Quy Fen Trust – Relevant Representation – 15th July 2023

1.0 Introduction:

1.1 Stow-Cum-Quy Fen is a Site of Special Scientific Interest (SSSI) located between the villages of Stow-Cum-Quy, Horningsea and Fen Ditton. Quy Fen Trust is the voluntary organisation responsible for preservation and upkeep of the fen.

Rev	Date	Drawn	Description	Ch'k'd	App'd																							
P1	07/11/22	JB	First Draft	PR	CS																								
Security	Status	Rev																											
STD	PRE	P1																											
						Figure 15.4

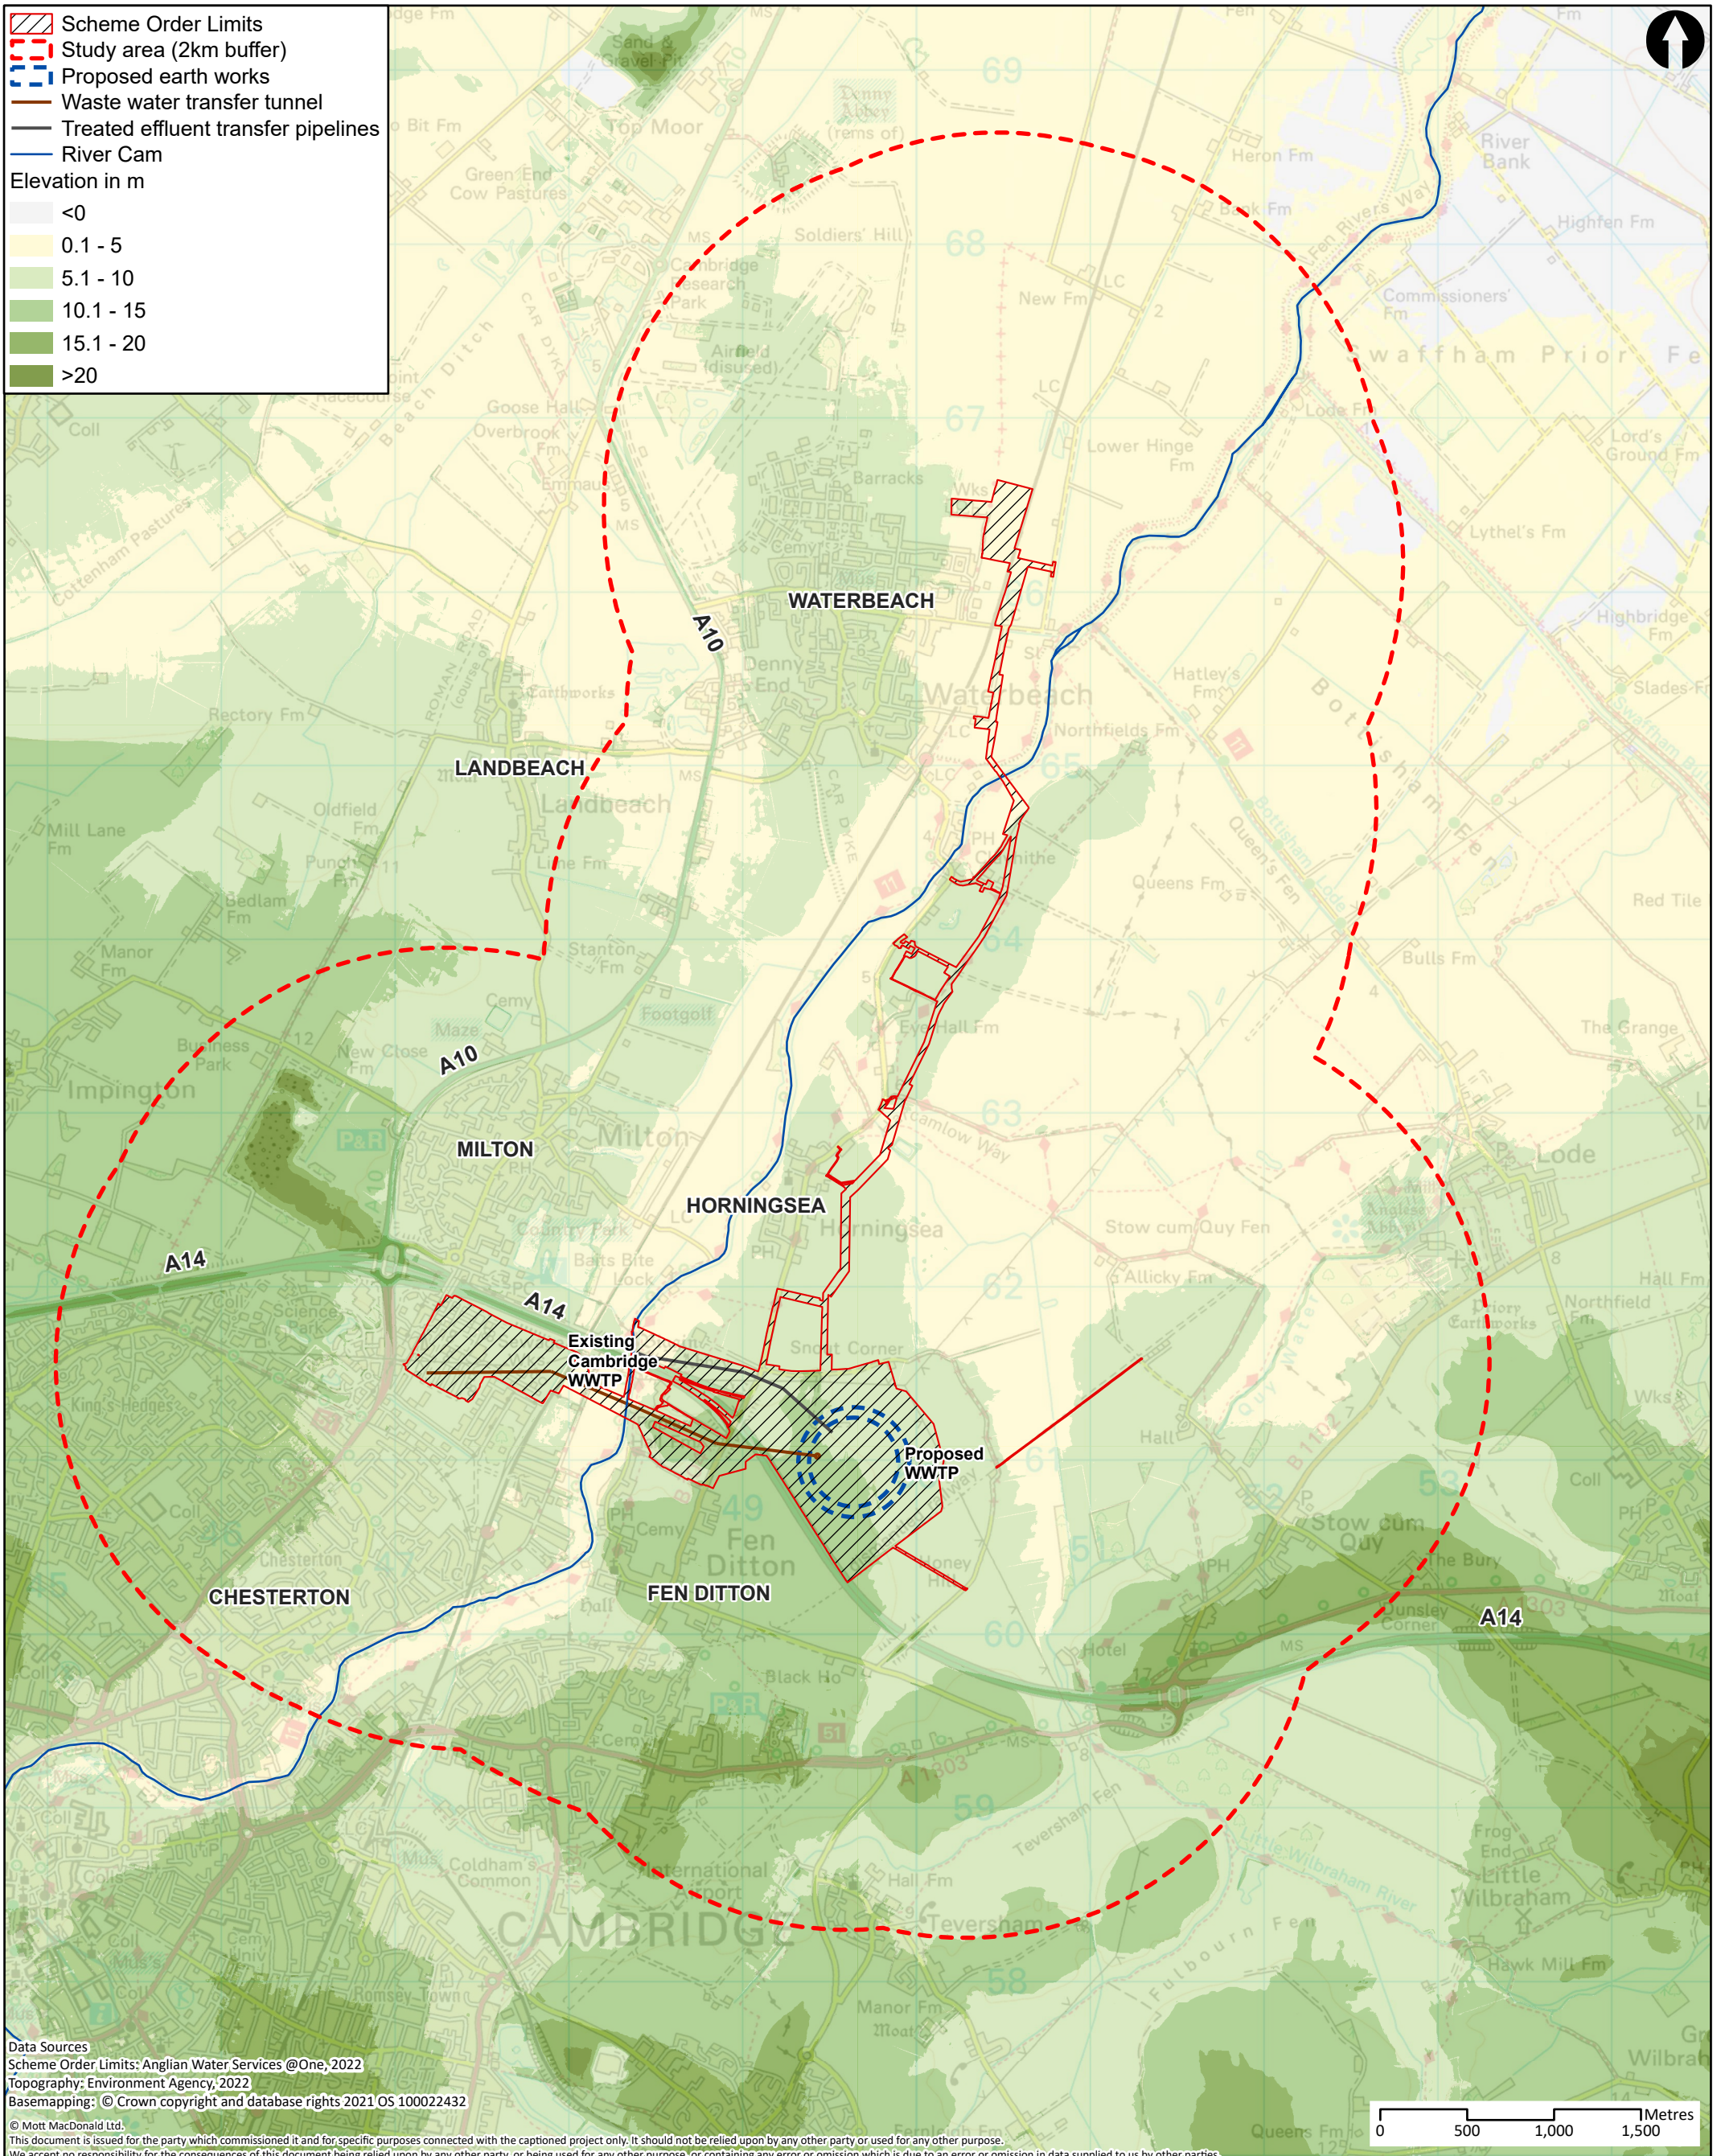
7.1 The footpaths and bridleways leading to Stow-Cum-Quy Fen SSSI are vulnerable to impacts on the visual amenity from the proposed works through both visual intrusion and night time light pollution. Document 5.3.15 Book of Figures Landscape and Visual Amenity Figure 15.4, shows the proposed site to be elevated by circa 10m from Stow-Cum-Quy Fen and the surrounding landscape, with the Zone of Theoretical visibility in year 1 of operation, Figure 15.1, highlighting the very open fenland landscape to the North East of the proposed site, towards the Fen and its surrounding footpaths and bridleways.
